# LANDSCAPE PLOT PLAN CHECKLIST

Support sheet  
PPR-19-55  
Snow Required

## LANDSCAPE PLOT PLAN

Site Development Plan for Wild Blue Animal Rescue

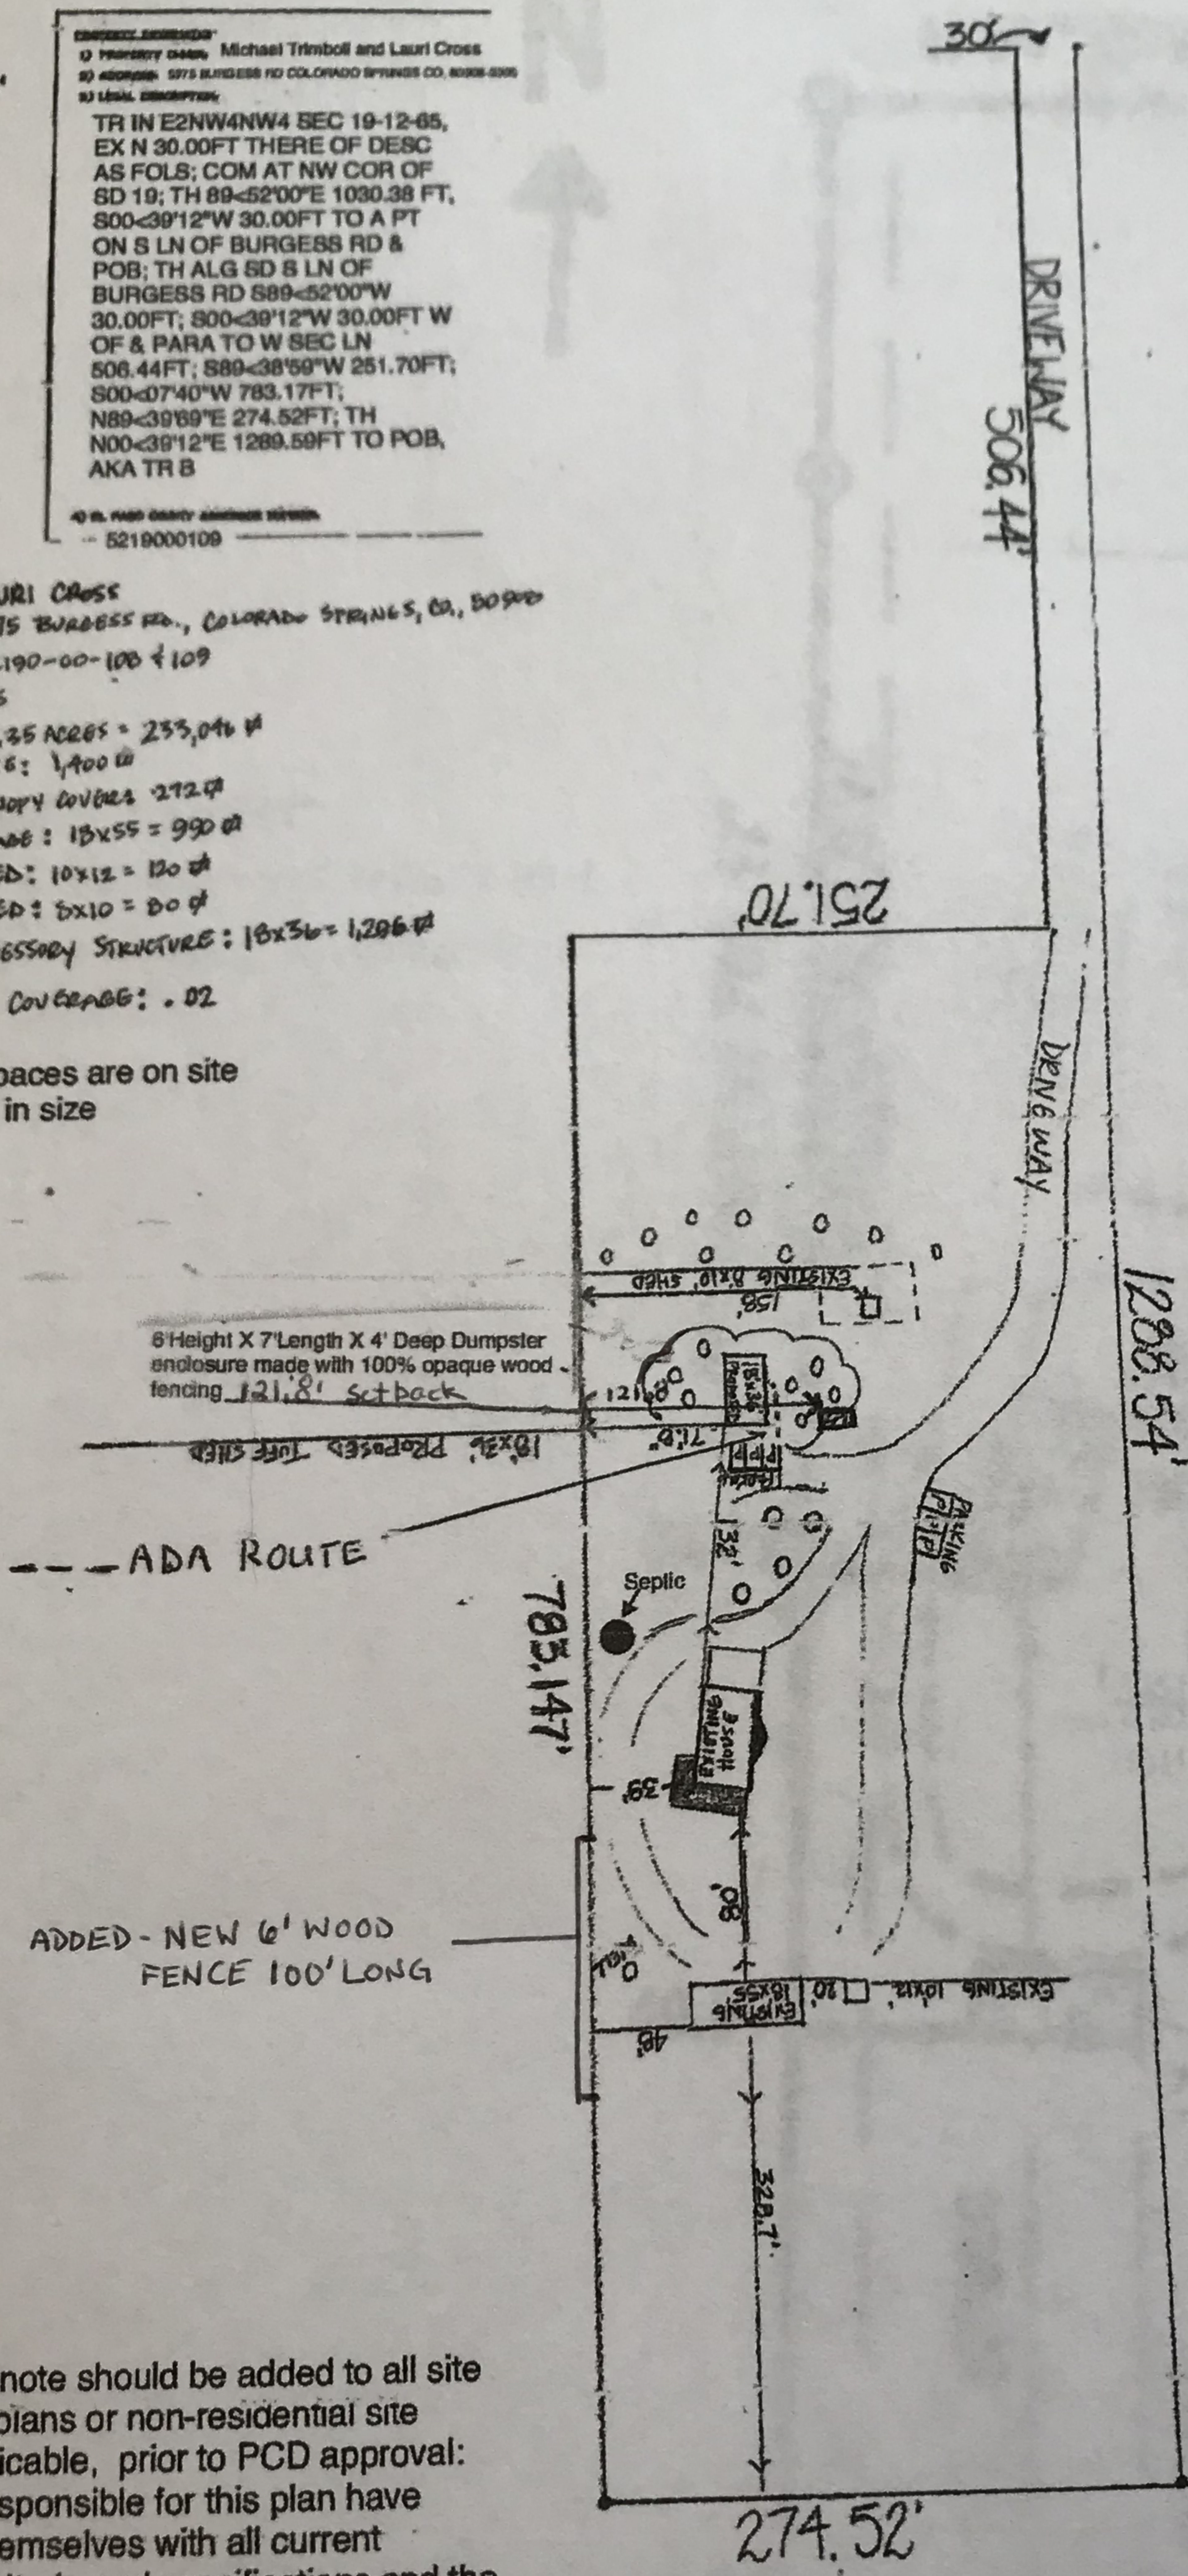
+ provided  
ASK for alternative  
plan for  
diffuse

existing  
+ new trees  
same  
to remain

Shrub  
oak  
to remain

show req. than show  
provided or existing
